Subject: FW: Y/17/20/PL - Land north of Yapton C of E Primary North End Road Yapton - Additional Repsonse

Subject: Y/17/20/PL - Land north of Yapton C of E Primary North End Road Yapton - Additional Repsonse

Client		
DANDARA LIMITED (SOUTHERN)		
Scale	Date	Designed
1:250 @A1	OCT 19	CJL
Drawn	Checked	Approved
CJL	SW	JHM
Job No	Drawing No	Rev
19-156	YAP-S278-01	D

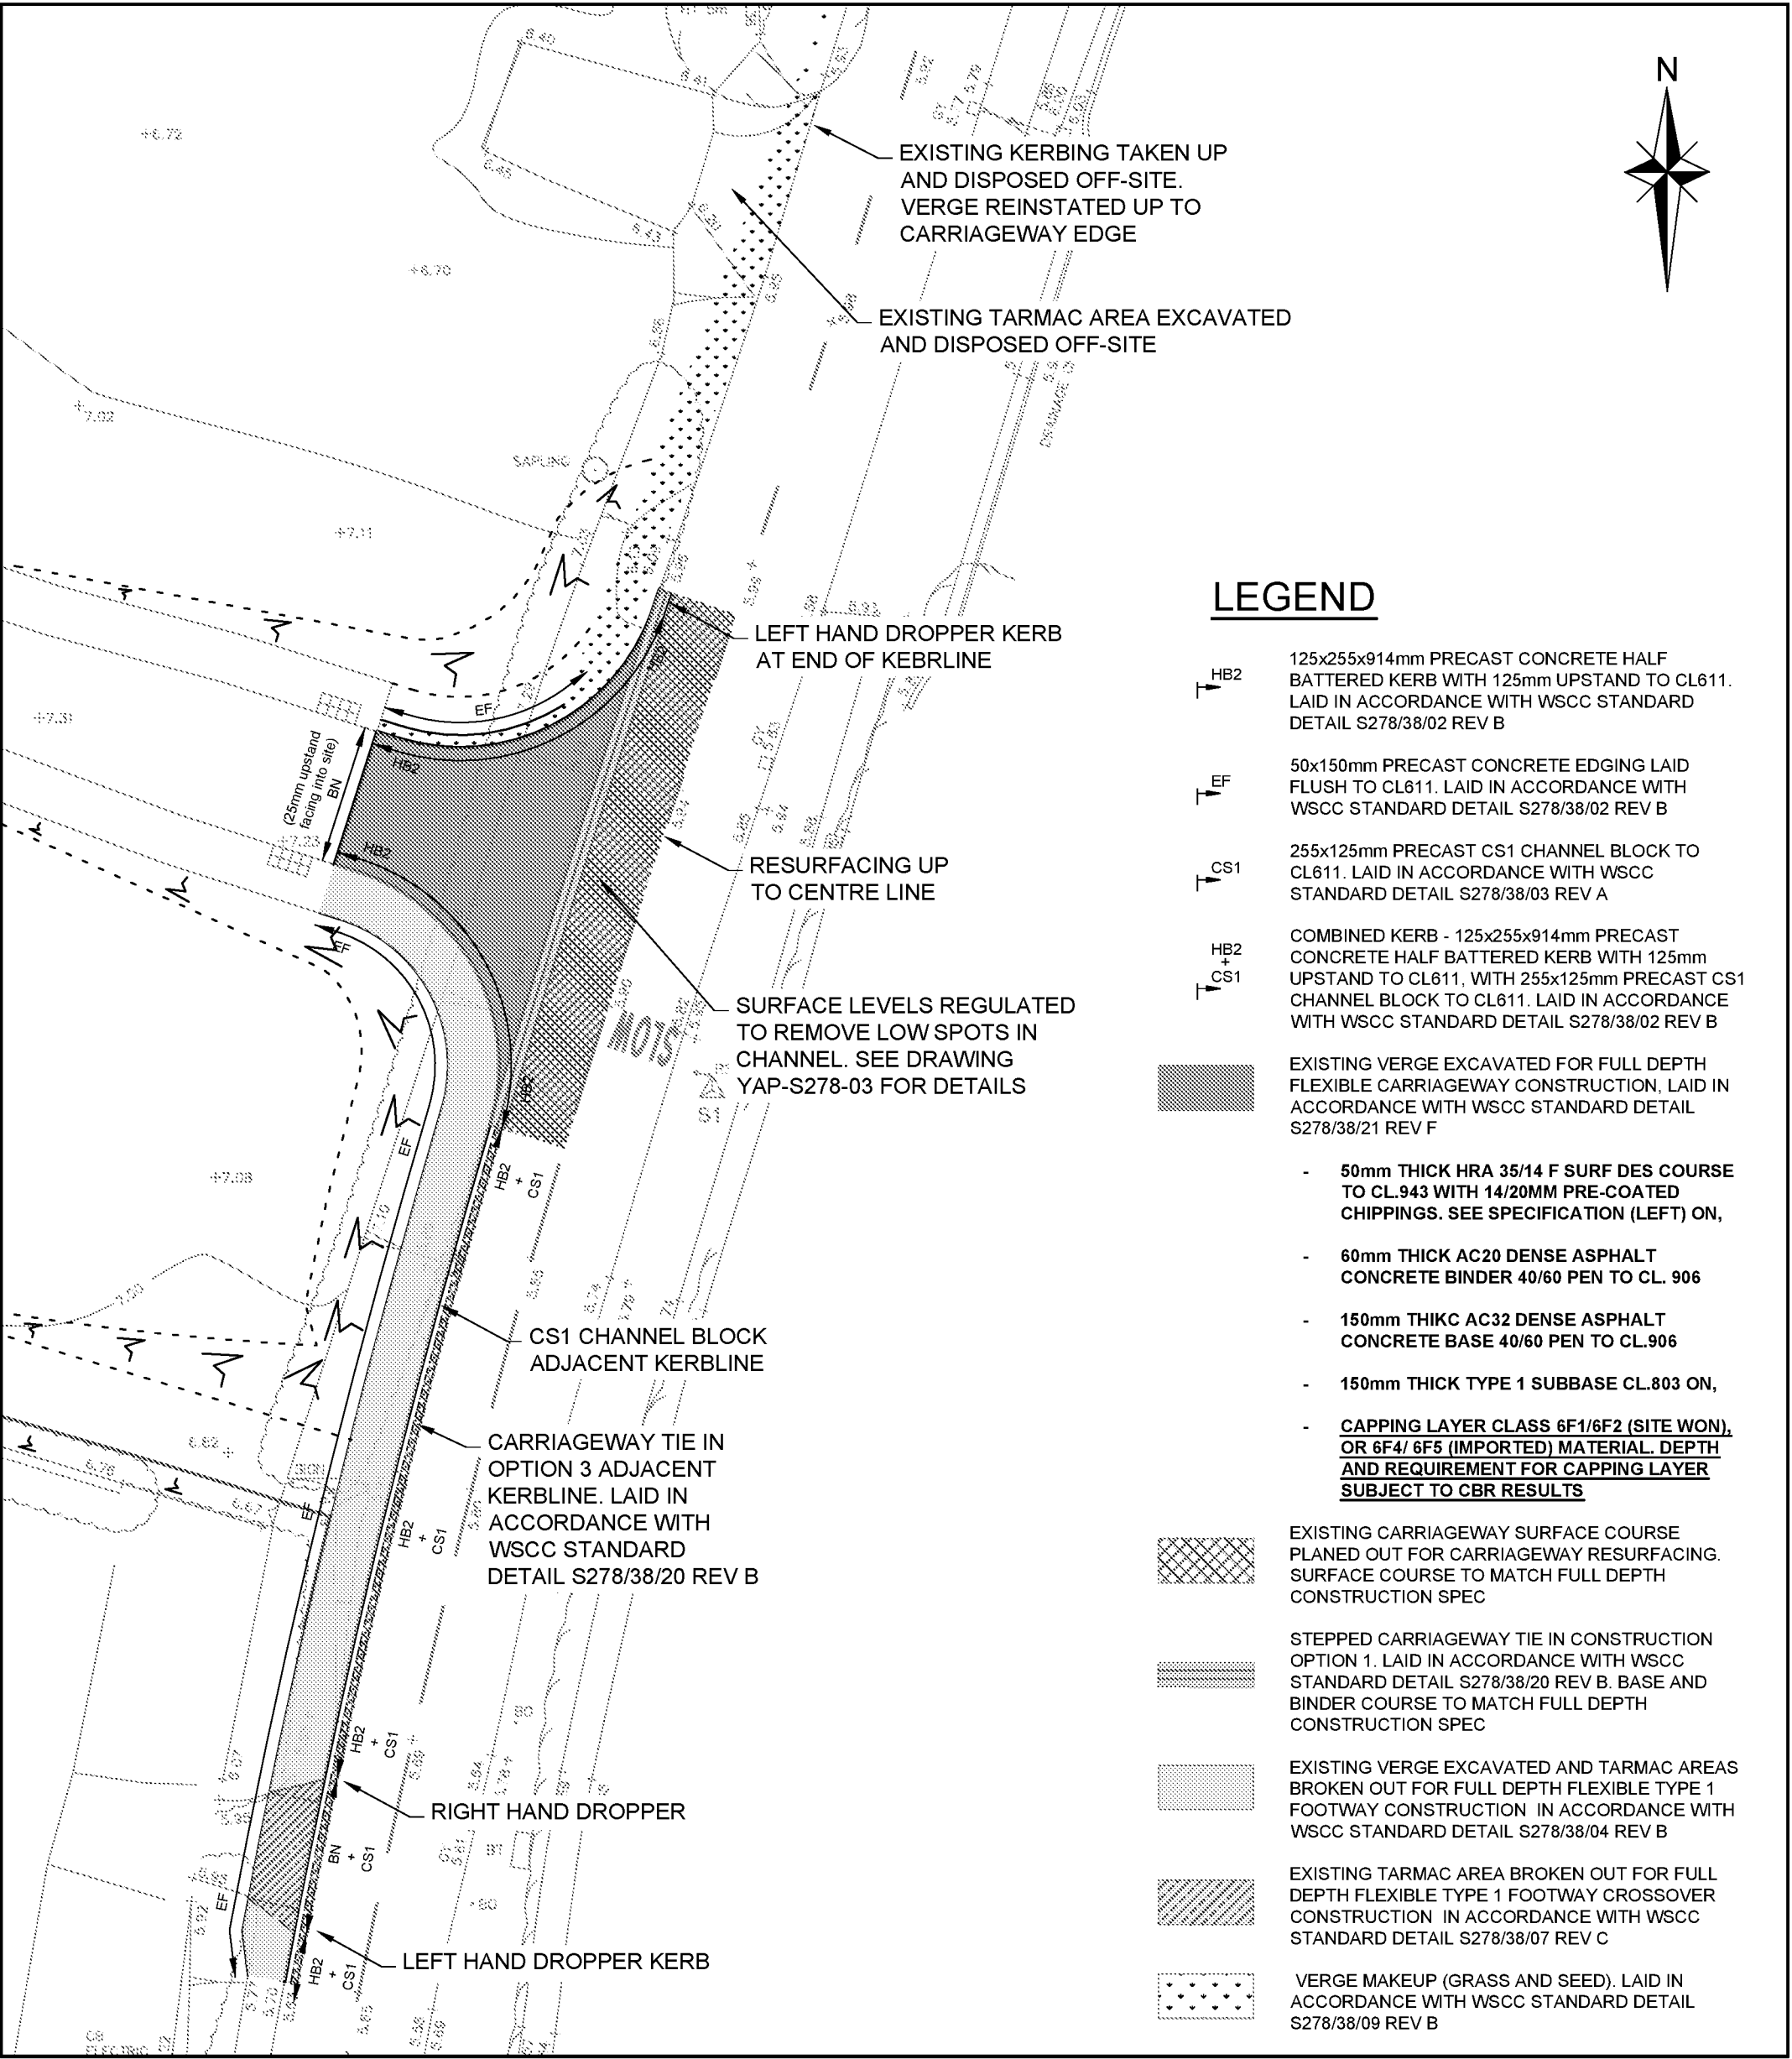
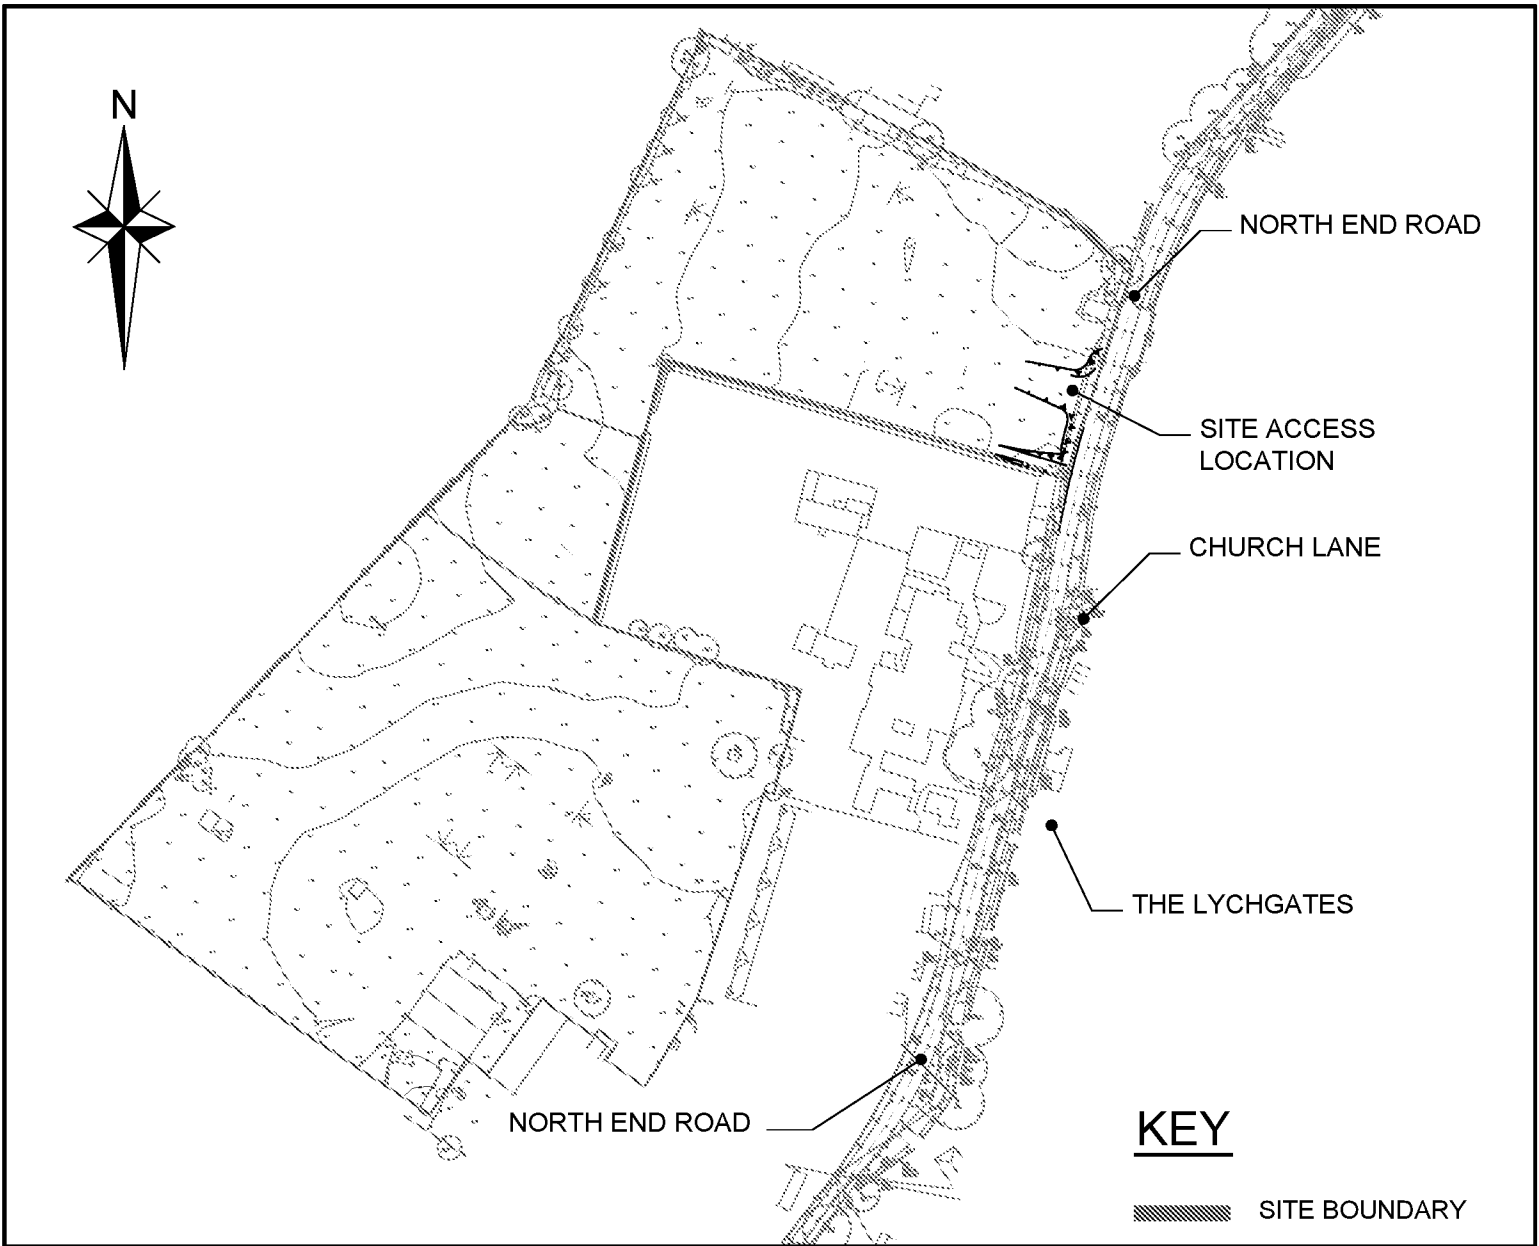
Re the visibility condition, you can't pin this on occupation. Are the vis splays shown on the drawings? I can't tell for sure. If they are, then the requirement to implement these would be covered by the standard plans condition. We could then seperately have a condition that simply stated: "The visibility splays of 2.4 metres by 76m to the north and 2.4m by 67 metres to the south shall be permanently maintained and kept free of all obstructions over a height of 0.6 metre above adjoining carriageway level"

If they are not shown on the drawing, we request that they are put on the drawing and then follow the same approach. Or we could have a condition worded to require that the vis splays be provided before first use of the access.

Given the principle of the application (access only) I would appreciate some advice on how the access can, if possible, be conditioned. The submitted plan (YAP-S278-01 Red D) is subject to change while it goes through the S278 process. As such any access condition would need to be 'with plans and details to be submitted to and approved by the LPA'. Once the Section 278 Agreement had reached the Technical Approval stage it is these plans

Outline Application Y/88/18/OUT proposed Access Arrangements

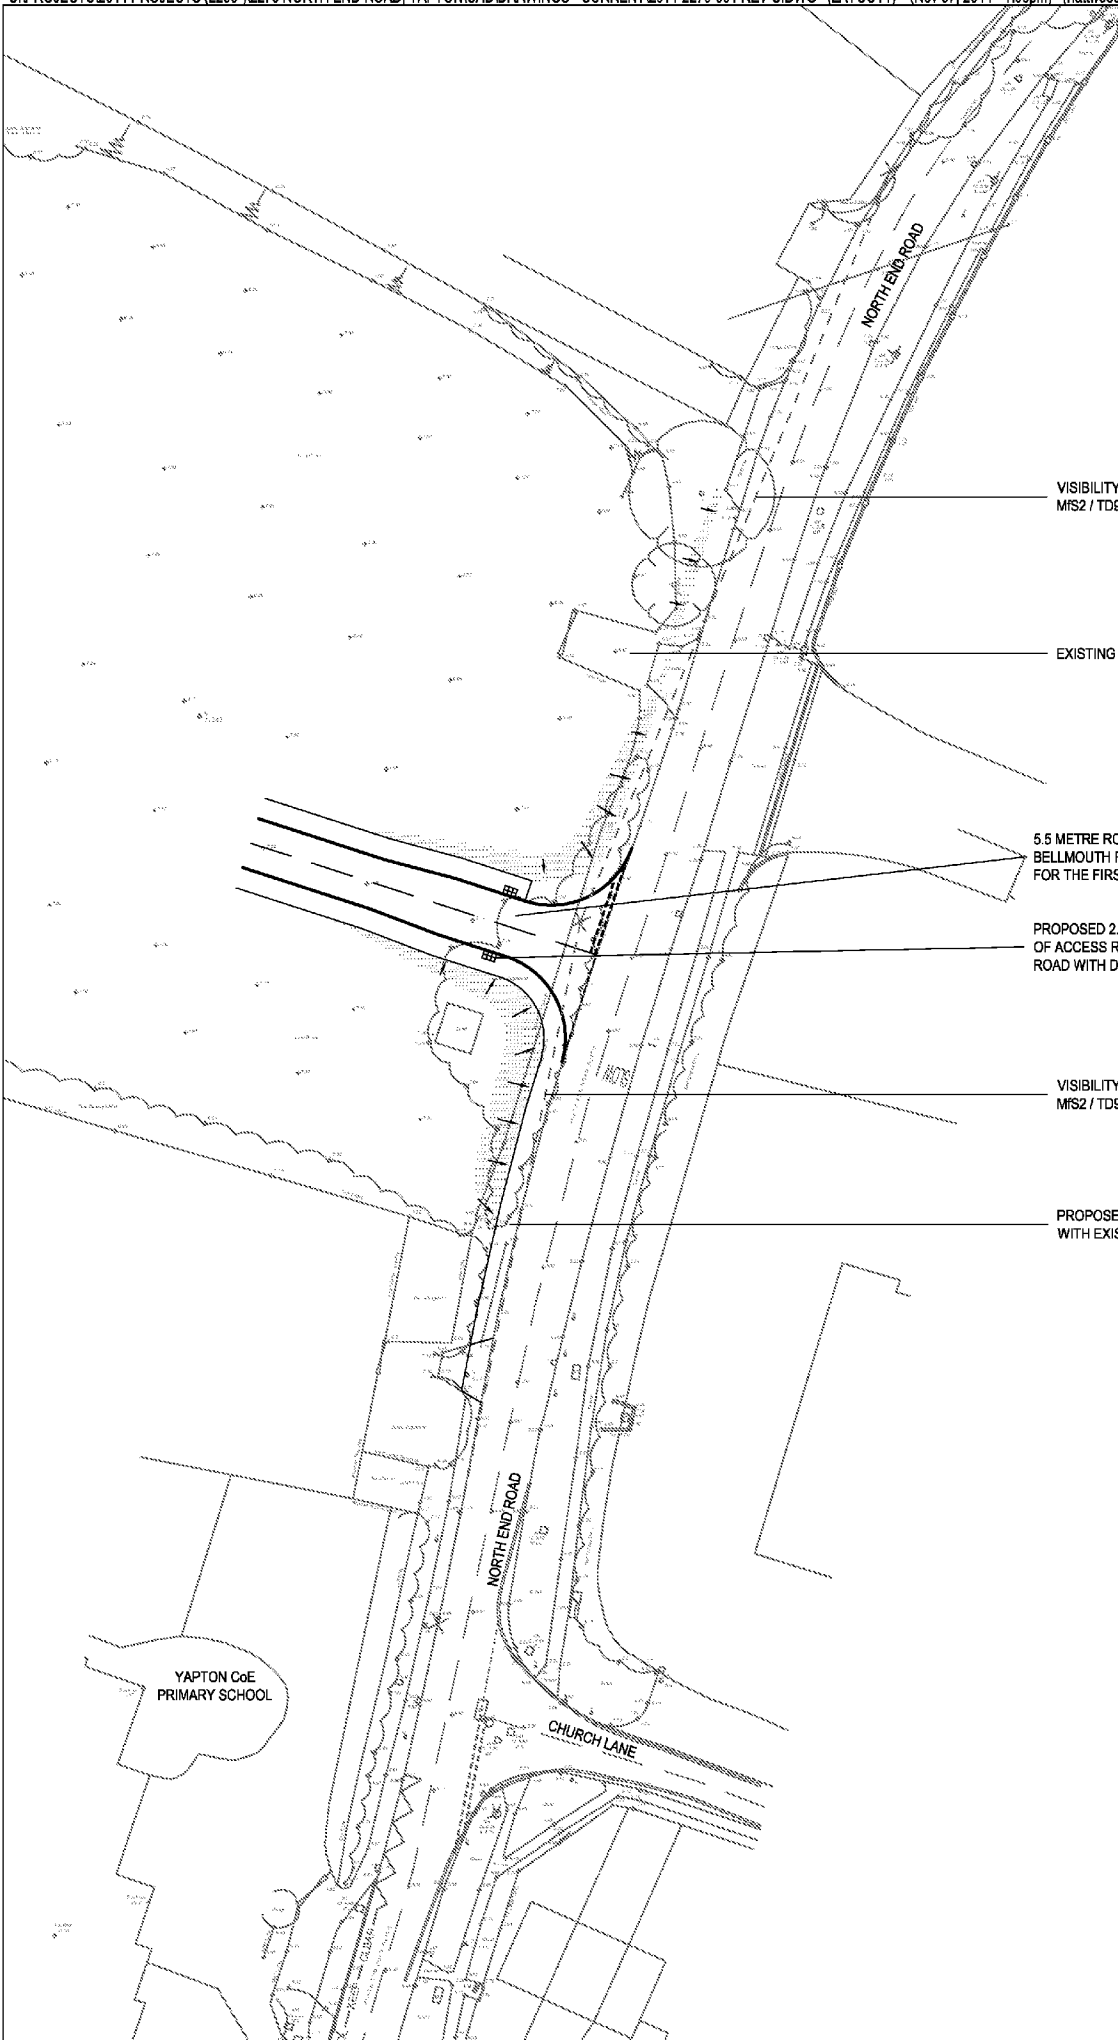
Note that this condition was imposed on the outline Y/88/18/OUT: *No development shall commence until the vehicular access serving the development has been constructed in accordance with the approved "Proposed Access Arrangement" drawing 2014/2270/001 Rev C.*

That condition would not technically have allowed for any change via the s278 process but as I understand from Ellie White's email below, the S.278 on the Y/88/18/OUT permission has been agreed therefore there should be no reason to further amend the access. This would thus negate the need for a condition?
